From: Steve Worthington 
Sent: 15 August 2017 18:20
To: Paul Cann
Cc: Barber, Robert; Michael Eastham; Terry Seymour; 'Kennett, Darren'; Karren Johnston
Subject: RE: Land East of Hook Lane - Discharge of Conditions - Drainage information

1. Noted.
2.
 - a) Noted
 - b) Noted but 1.007 still has a different gradient to that shown on the plan.
 - c) Noted
 - d) Noted
 - e) 6.000 and 6.001 have different gradients to that shown on the plan.
 - f) Noted
 - g) Noted
 - h) Flooding is predicted on pipes 1.000, 1.001, 3000, 3.001, 2.002, 5.000, 5.001, and 1.003. Please advise of flood extents/depths. I assume available storage in the permeable paving/swales hasn't been allowed for in the calculations?
3. Could you point out in document where hydrobrake maintenance is covered and where it specifies the chosen pumping station alarm arrangement/notification.
4. Detail to protect the northern boundary noted, but I can't see how the eastern boundary will be dealt with in order to cater for surface runoff/ seepage through the bank, from the higher ground. I.e. perhaps an impervious clay barrier/French drain arrangement?

Drawing No. **BSO/E4462/454 C3**

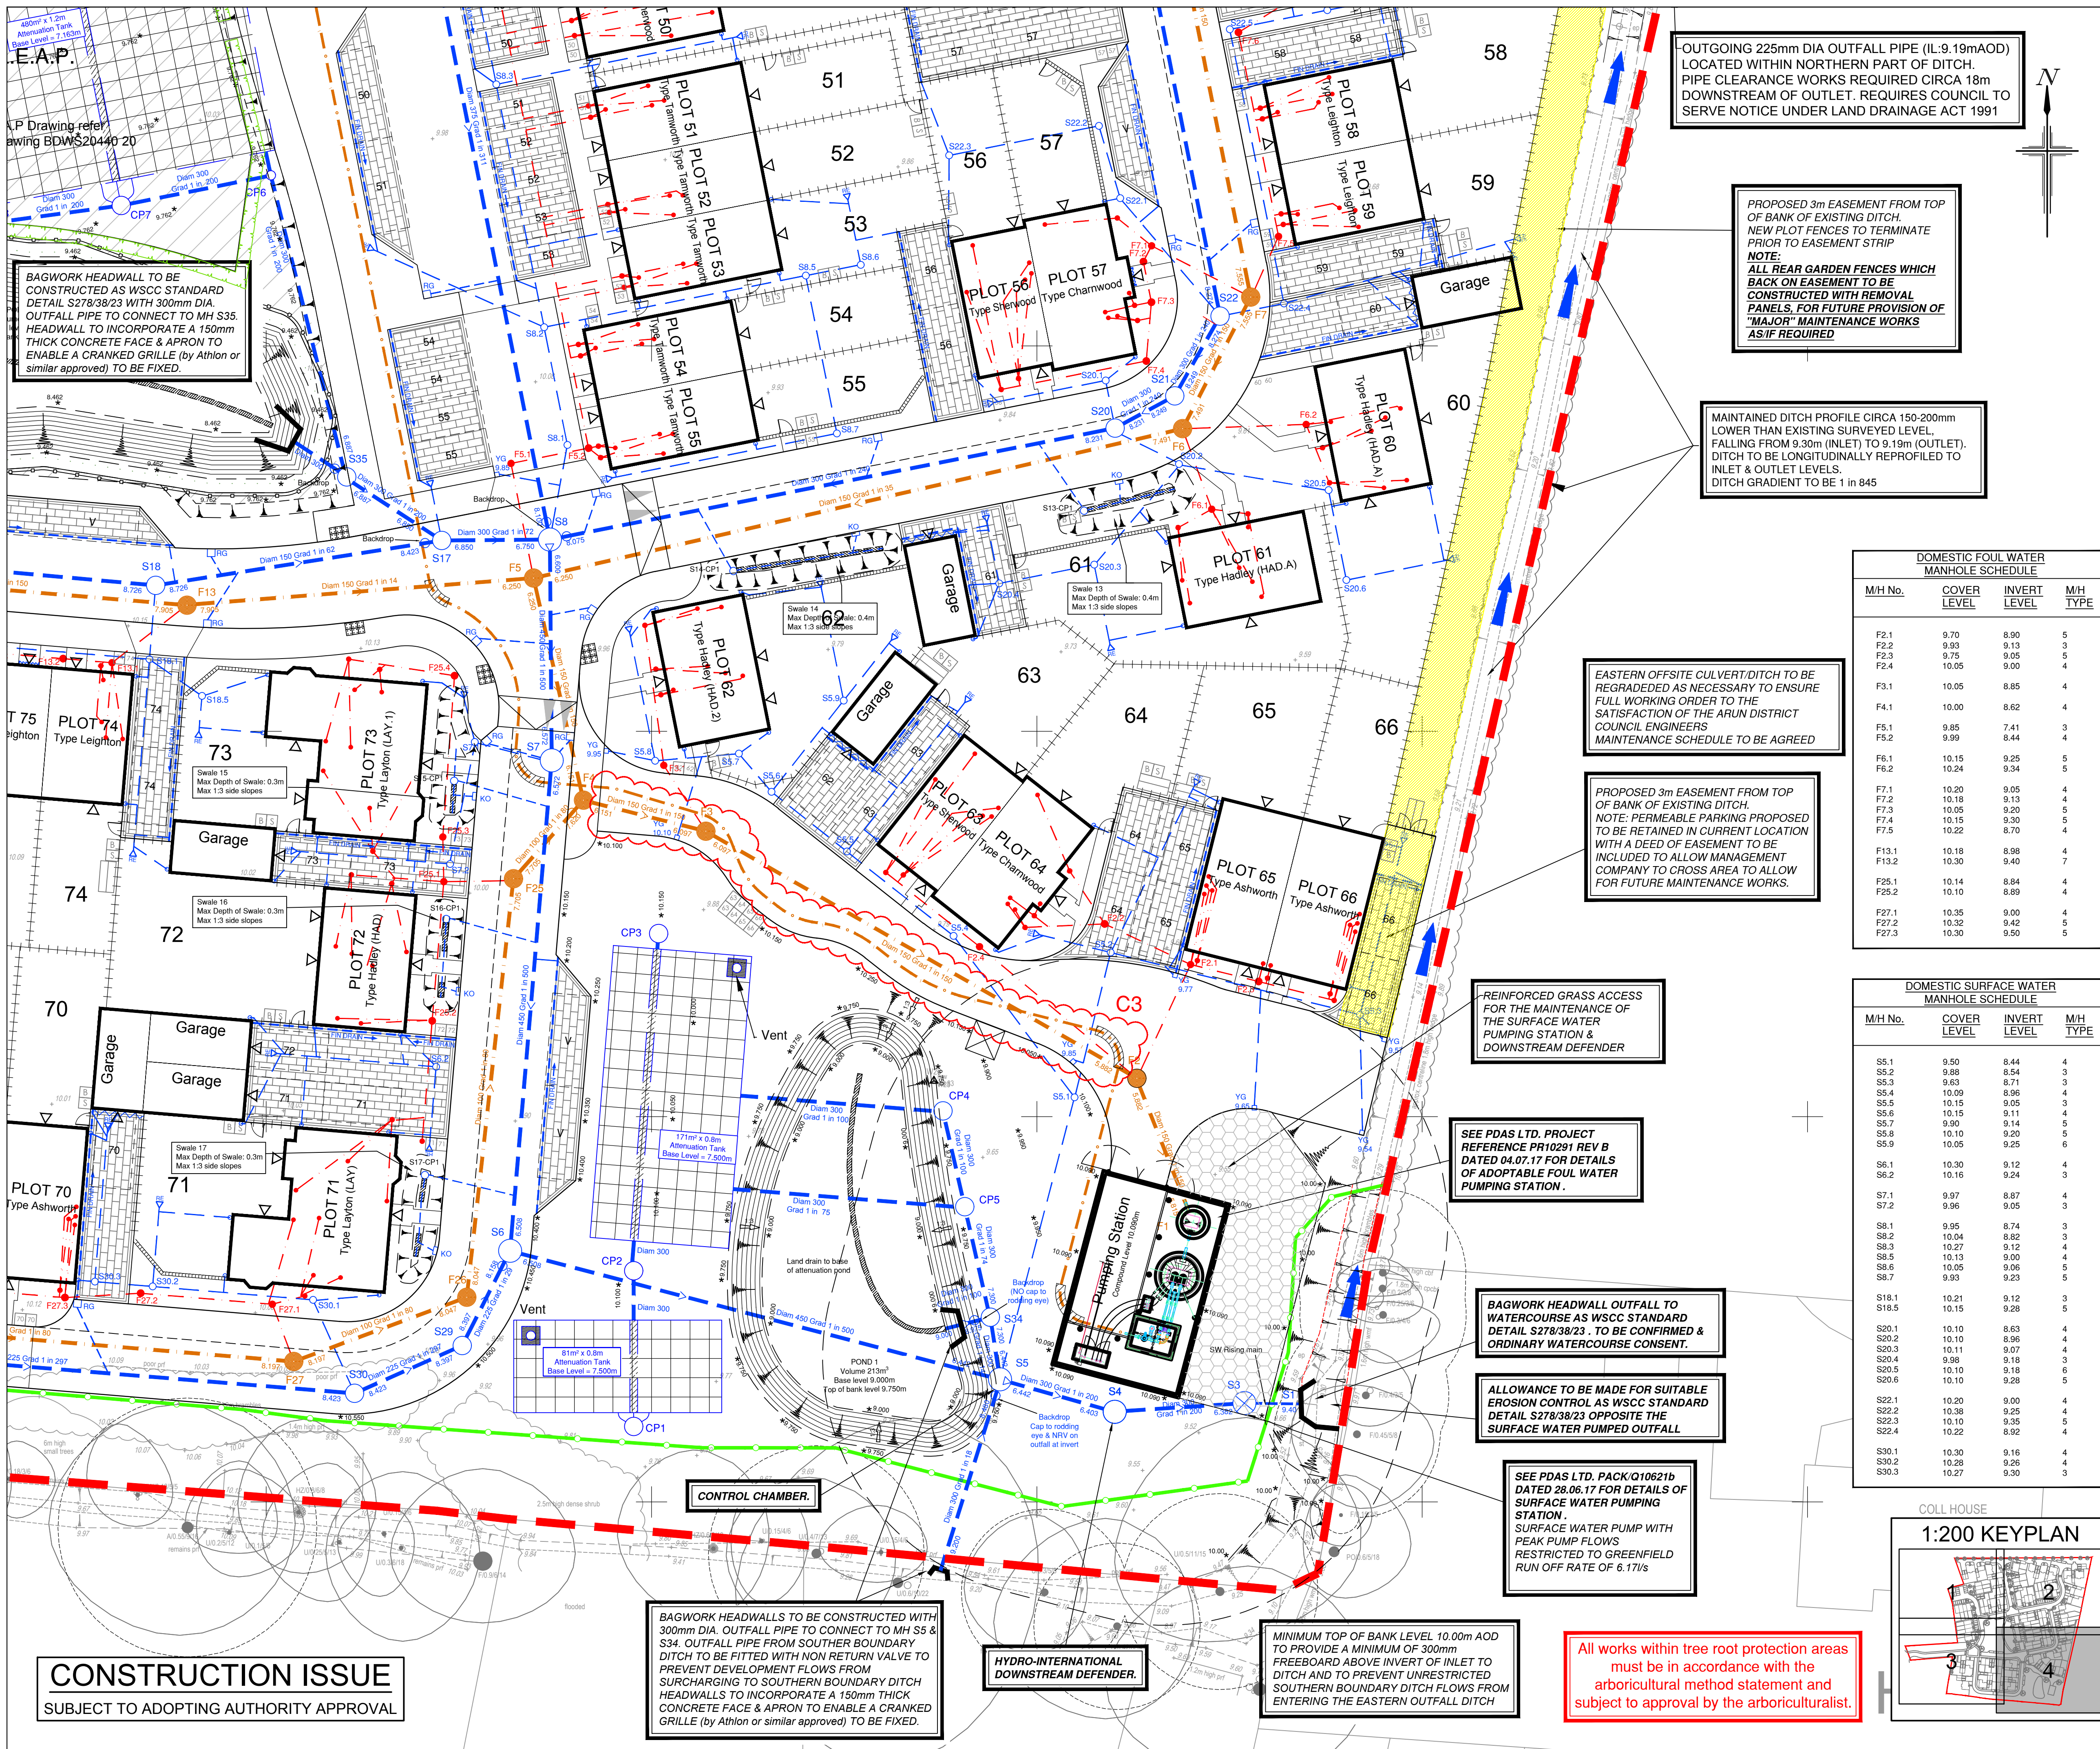
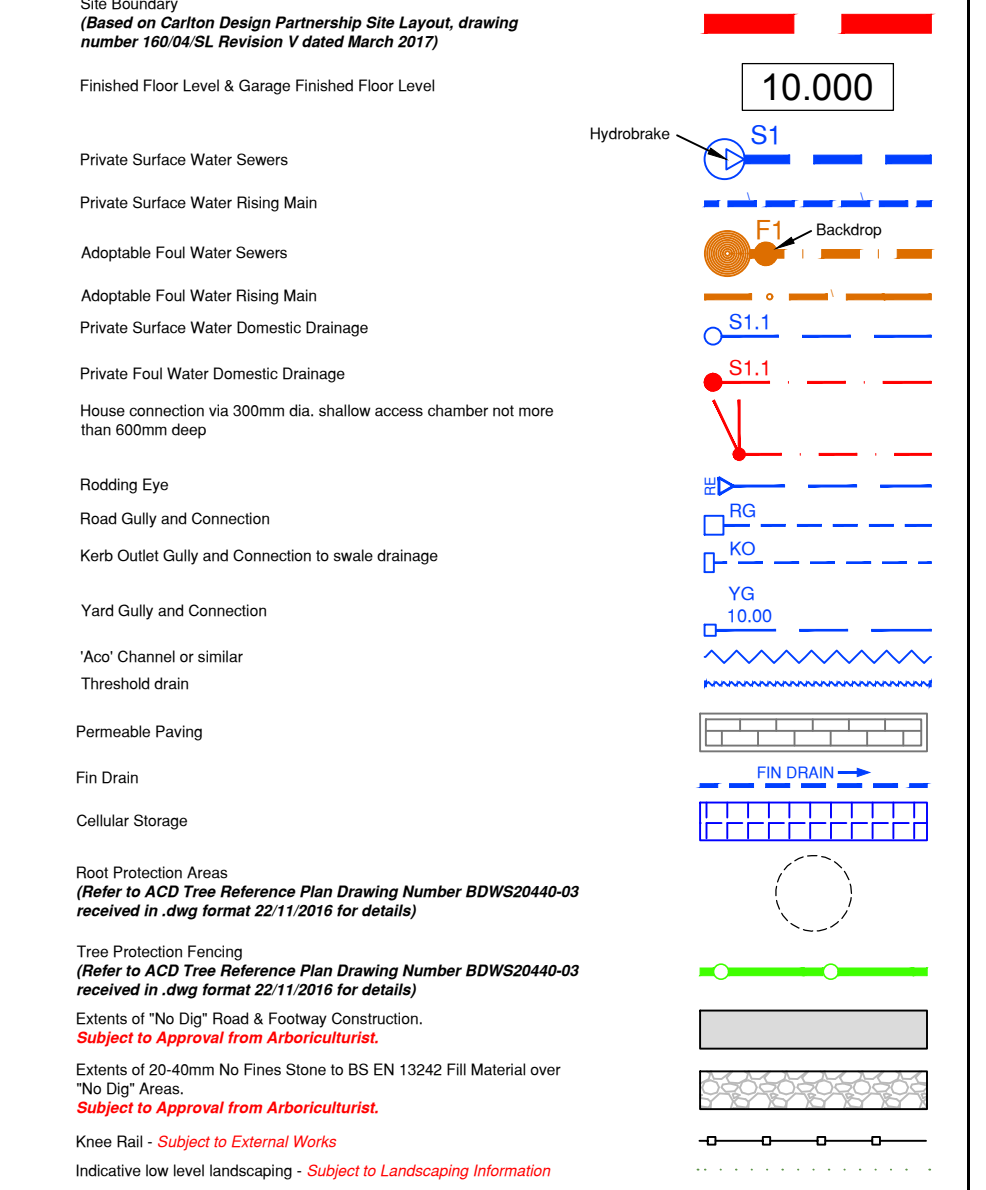
4. I don't think a fin drain is the answer as this could potentially move flows quicker to the lower areas and may not totally eradicate the chance of water passing to the lower ground In Cherry Trees during extreme conditions. An impermeable barrier built into the construction where adjacent to the northern and eastern boundaries of Cherry Trees should be considered. A detail will be required.

Your point 4 is addressed on Drawing 453 C3
